DRB CASE ACTION LOG - BLUE SHEET

Project #: 1005141 Application #: 12DRB-70328
Project Name: Panorama Heights
Agent: Cartesian Surveys Inc. Phone #:

**CITY OF ALBUQUERQUE
PLANNING DEPARTMENT
October 24, 2012
DRB Comments**

RE: Lots L-1-A thru L-1-C, Block 11, Panorama Heights

**Plat for  
Tracts L-1-A-1 and L-1-B-1  
Block 11, Panorama Heights  
Being Comprised of Tracts L-1-A  
L-1-B & L-1-C, Panorama Heights  
City of Albuquerque  
Bernalillo County, New Mexico  
September 2012**

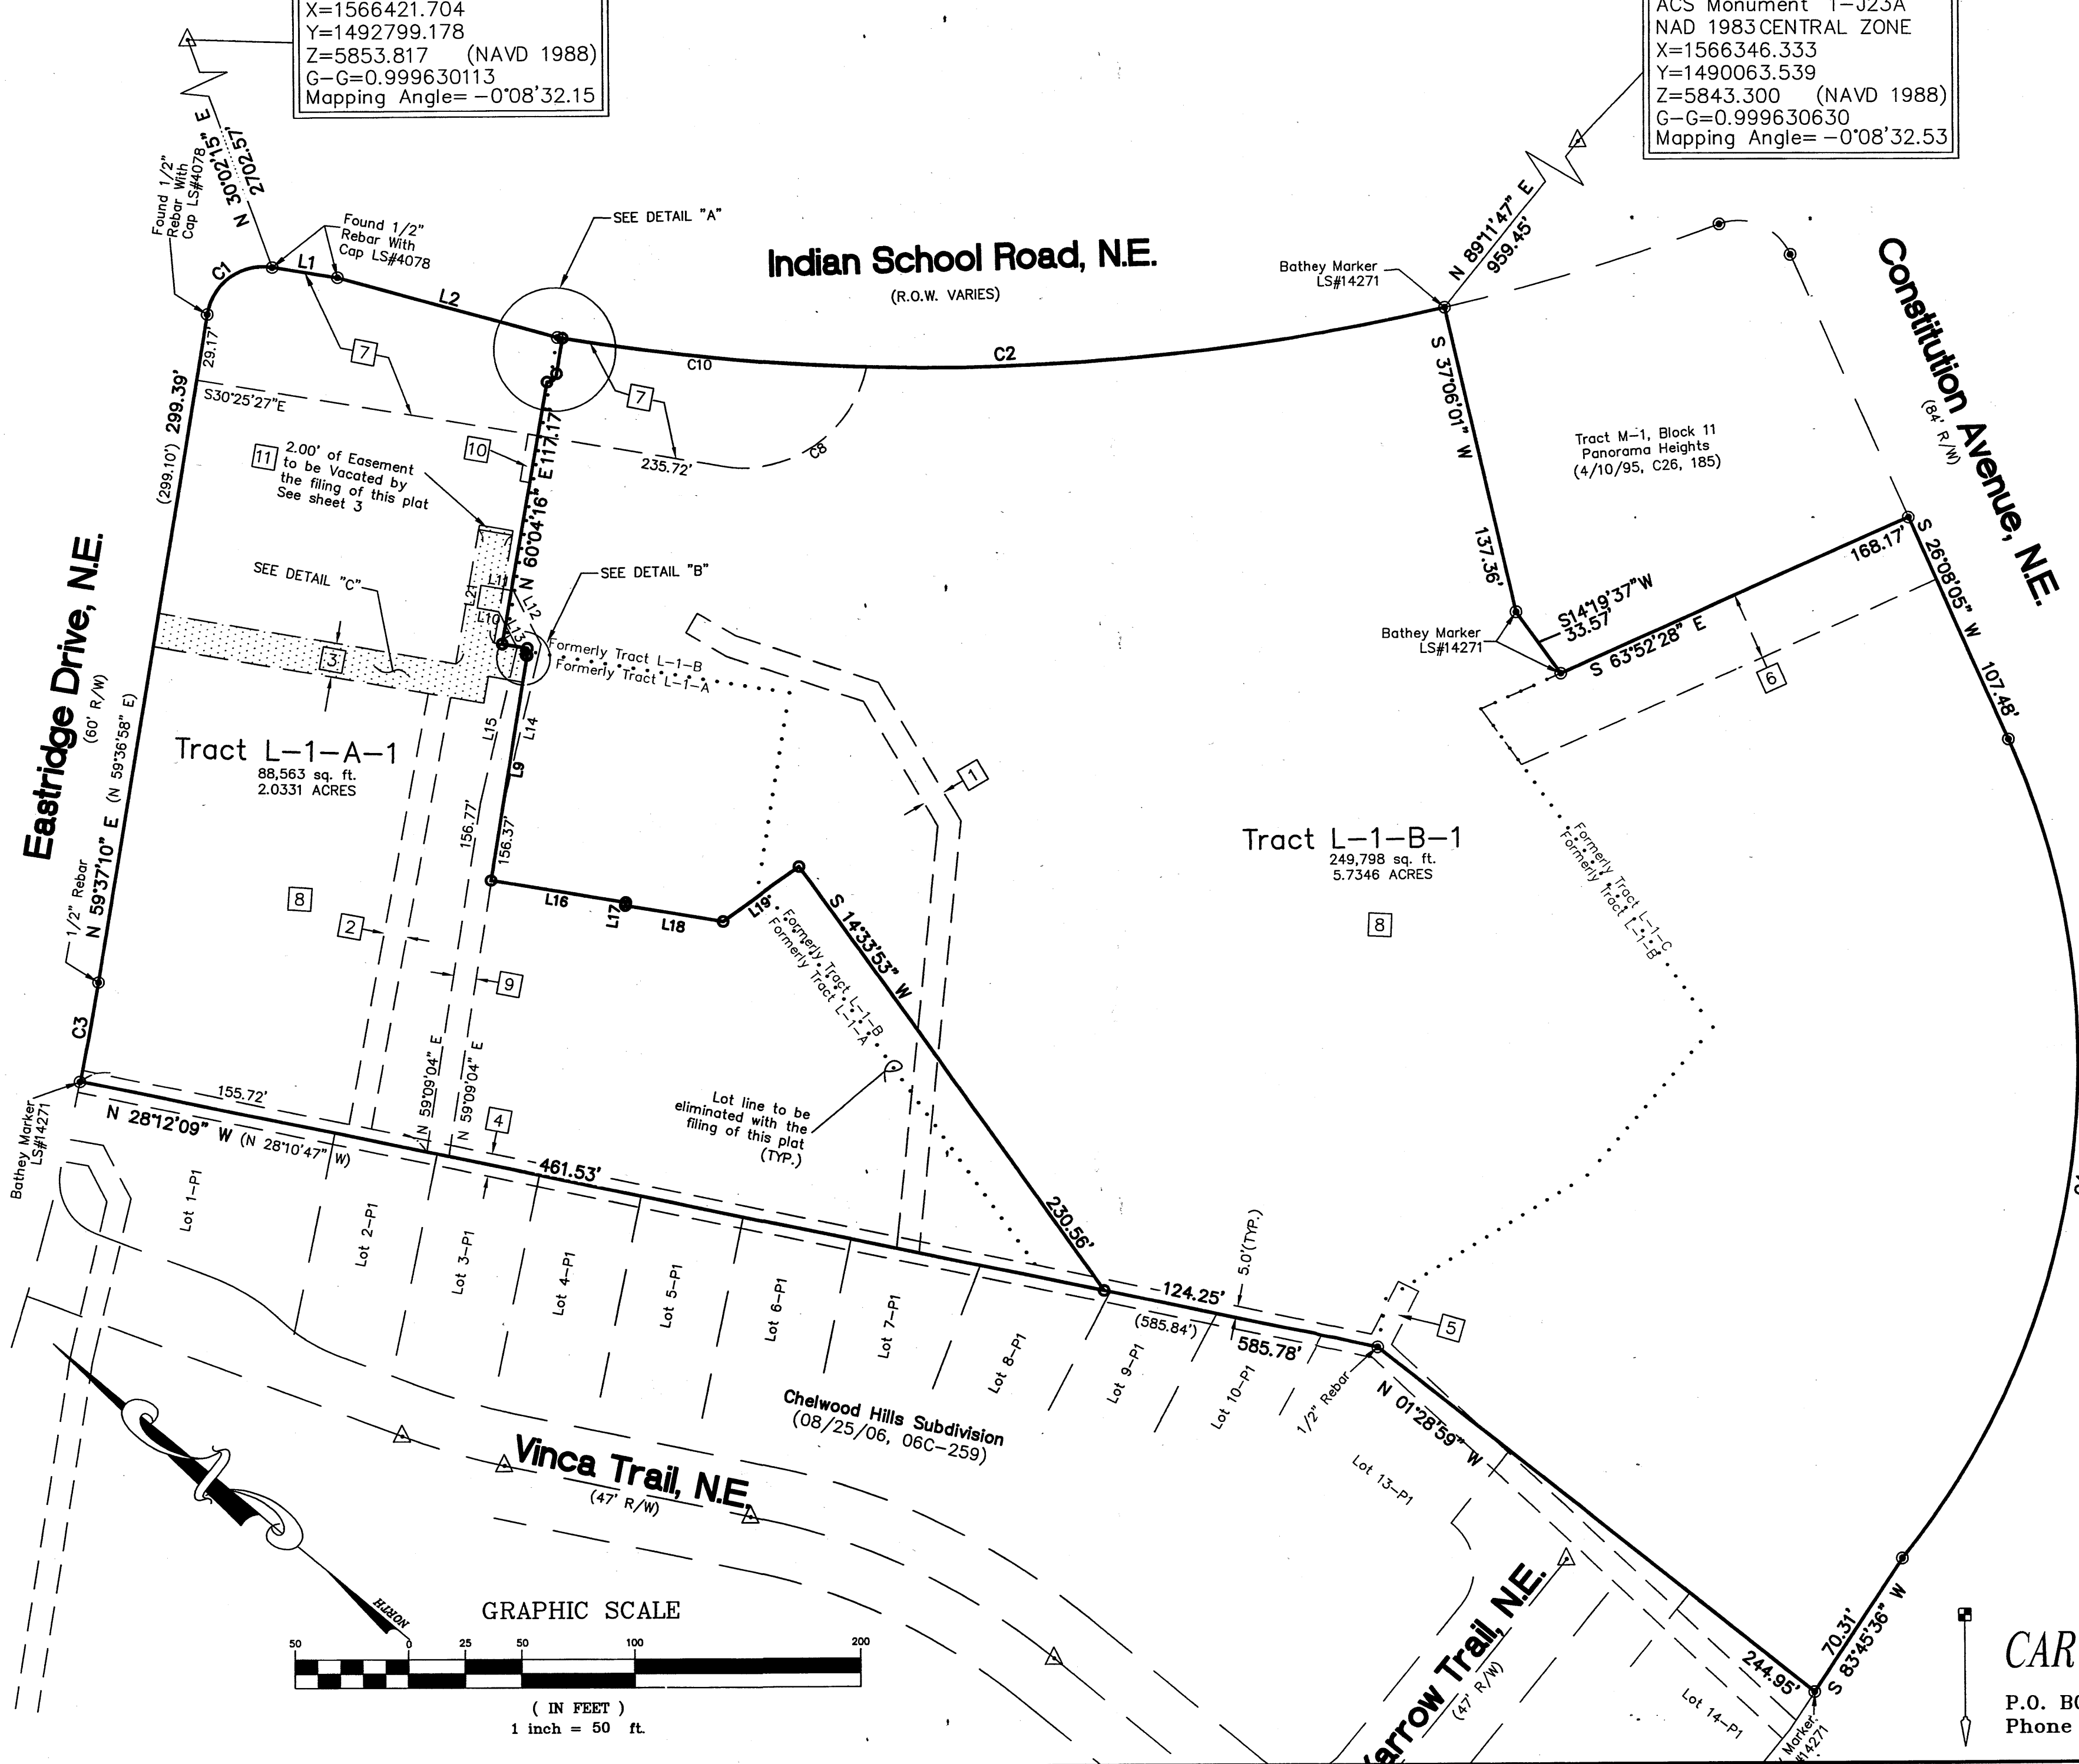
Vacation of platted easements requires a separate application for vacation (Form V), and payment of associated fees. Certification by a licensed architect or engineer is required to document that the existing buildings comply with the building and zoning codes regarding the proposed property lines.

**Sketch Plat for**  
**Tracts "L-1-A-1" & "L-1-B-1"**  
**Panorama Heights**  
 Being Comprised of Tracts "L-1-A"  
 & "L-1-B", Panorama Heights  
 City of Albuquerque  
 Bernalillo County, New Mexico  
 September 2012

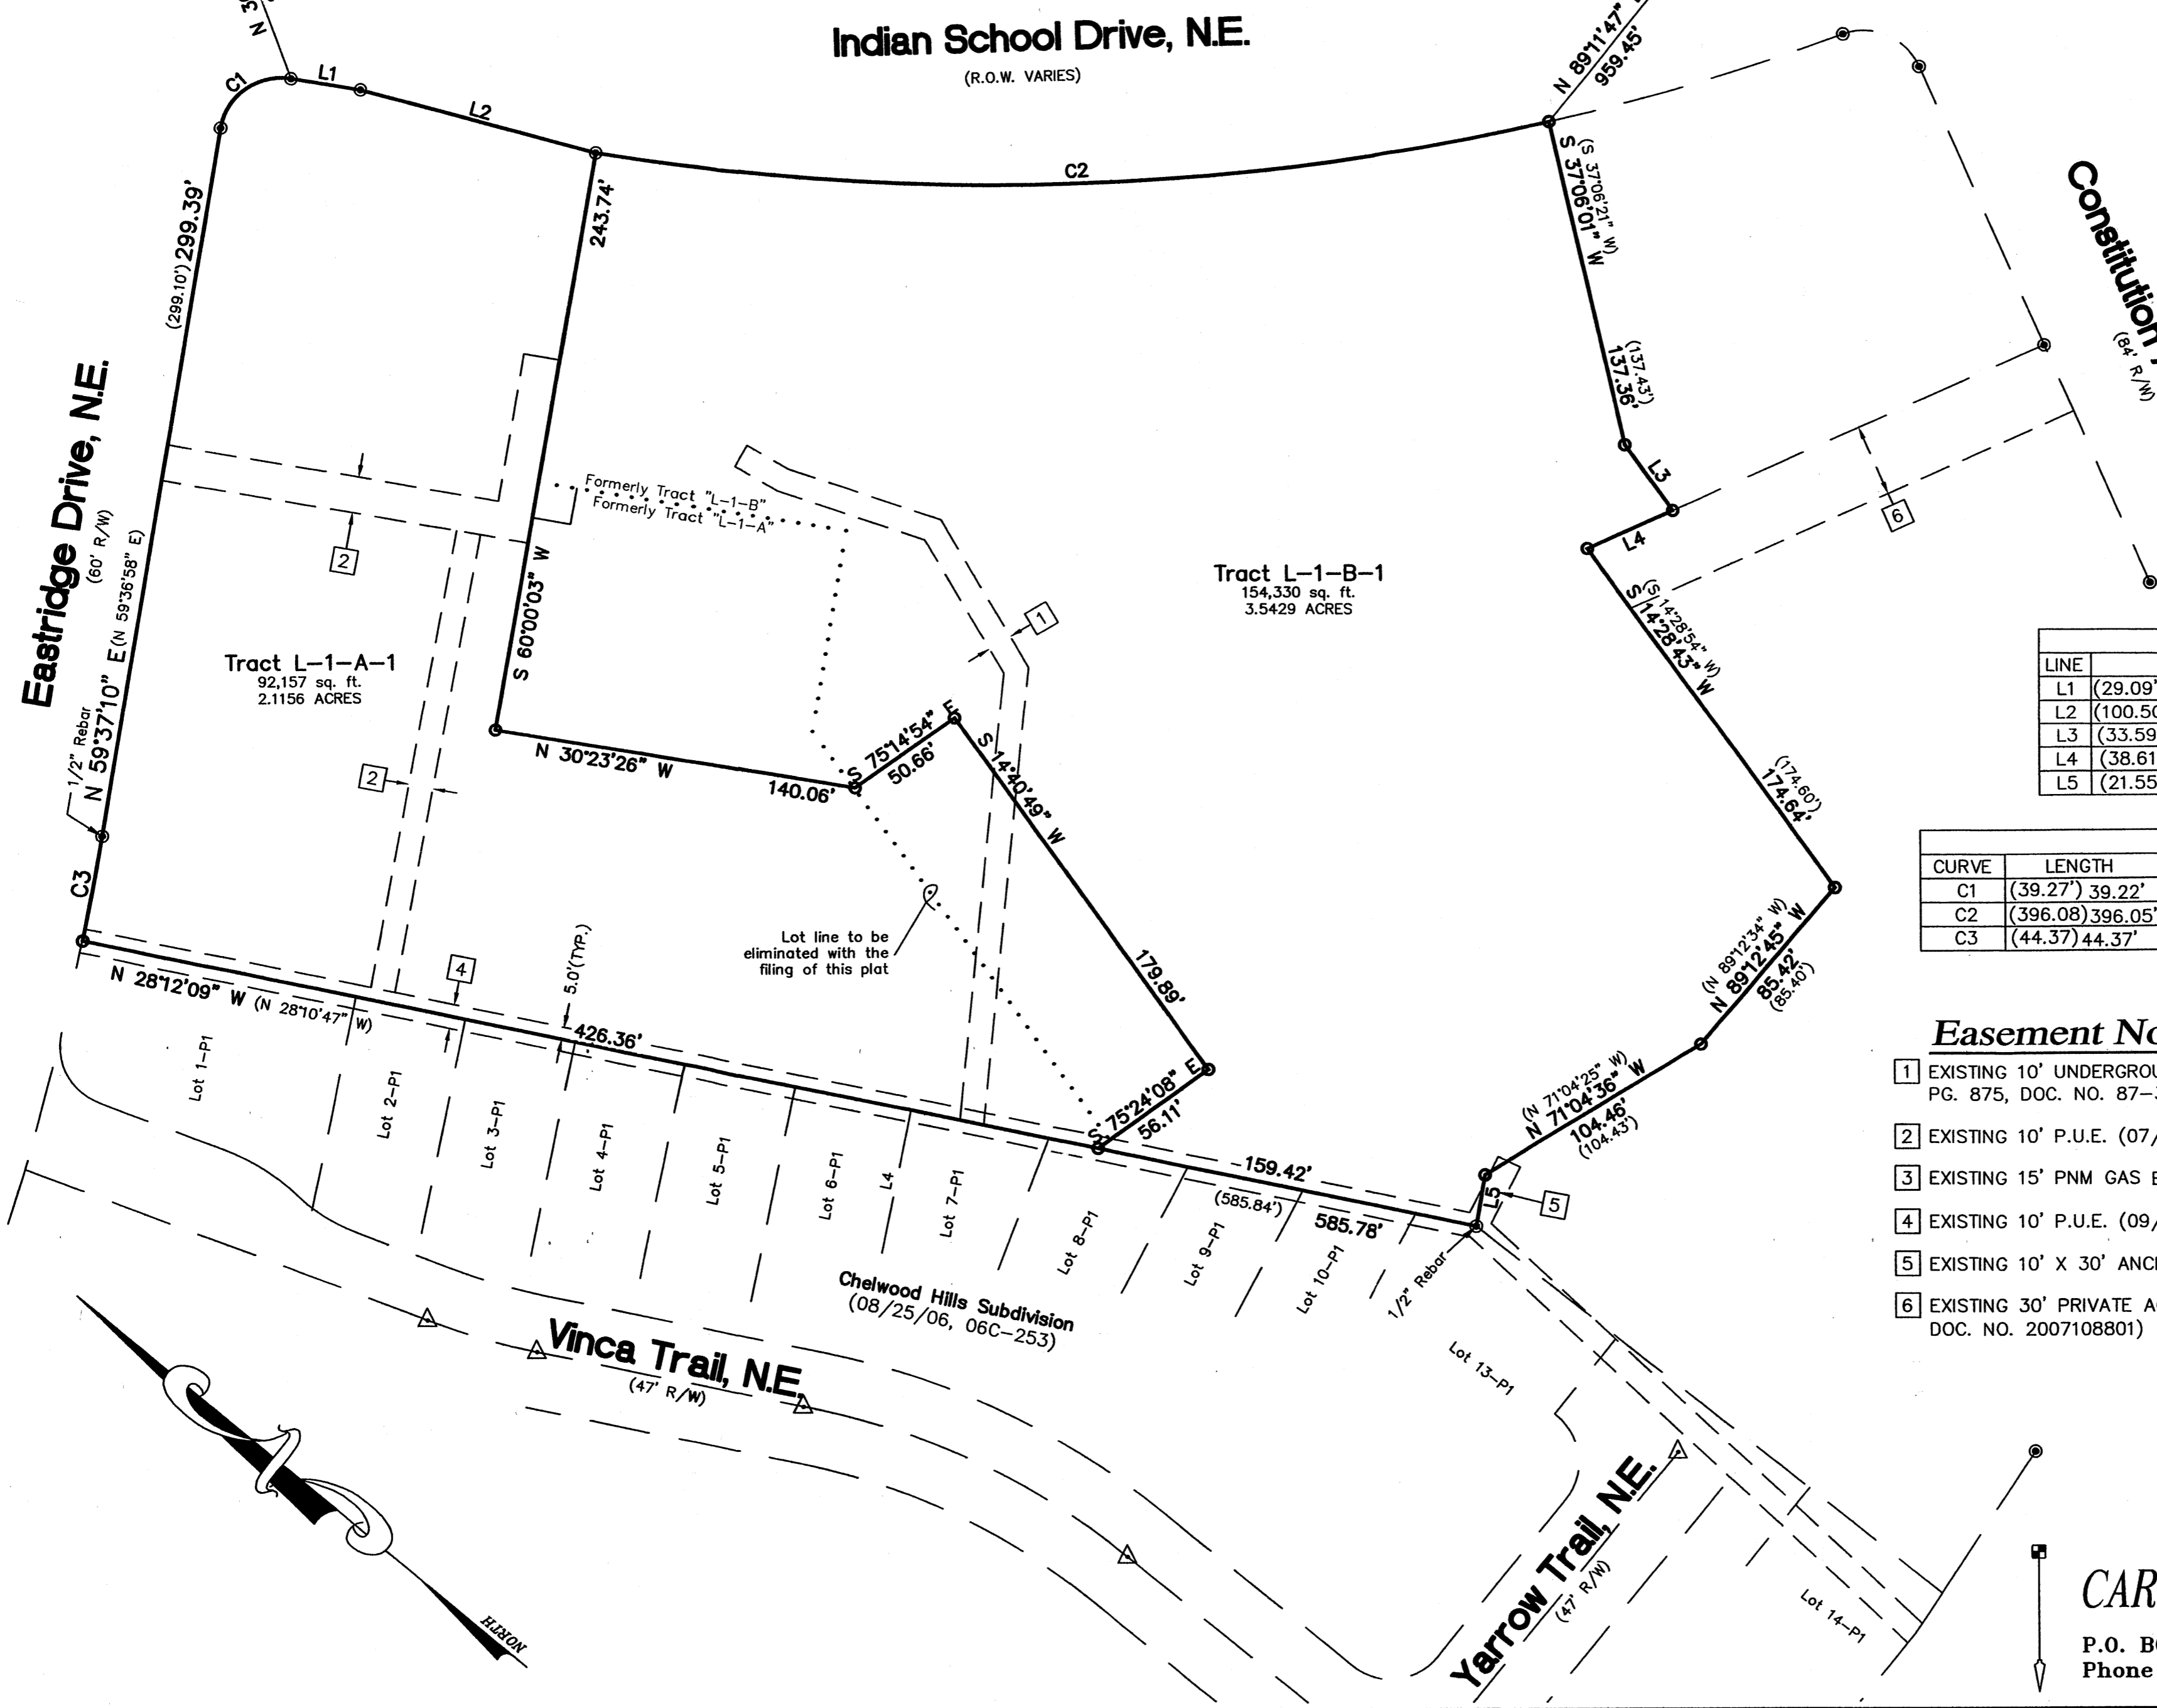
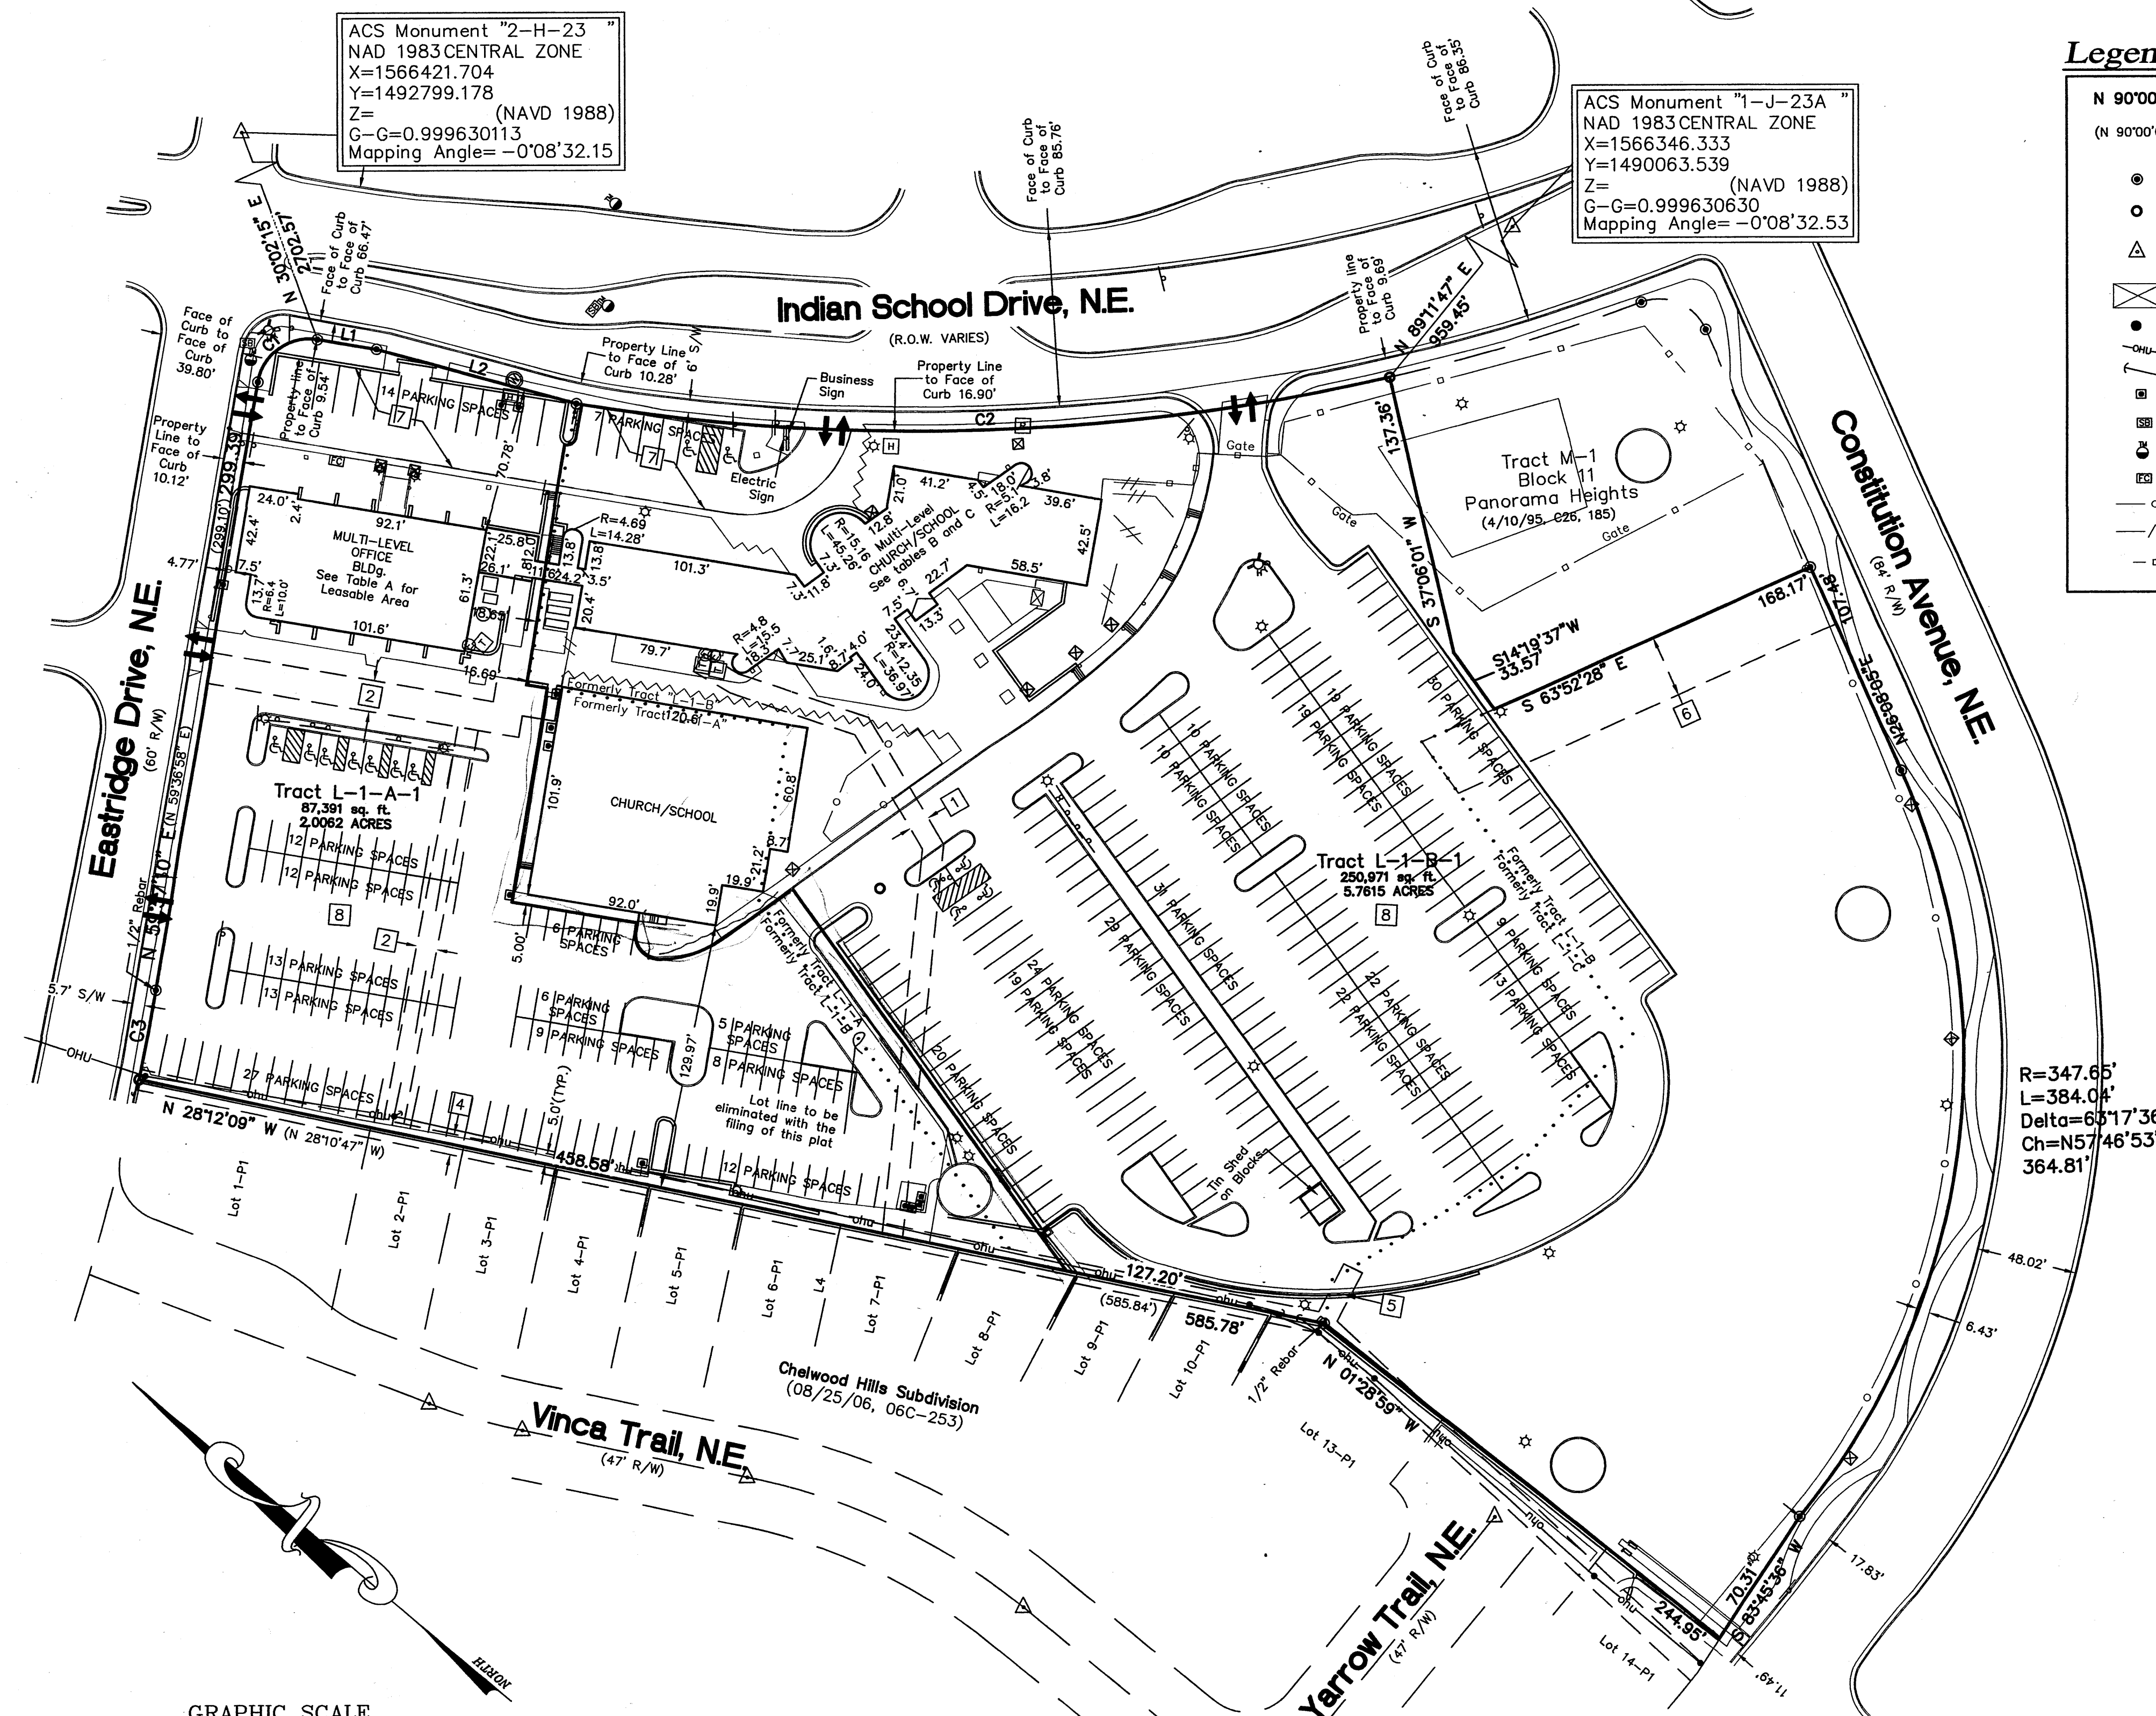
Reciprocal access, drainage and parking easements will be needed (this will need to include Tract L1C unless it was on previous plat). Parking calculations are needed to demonstrate that each new lot meets the on-site parking requirements of the Zoning Code.
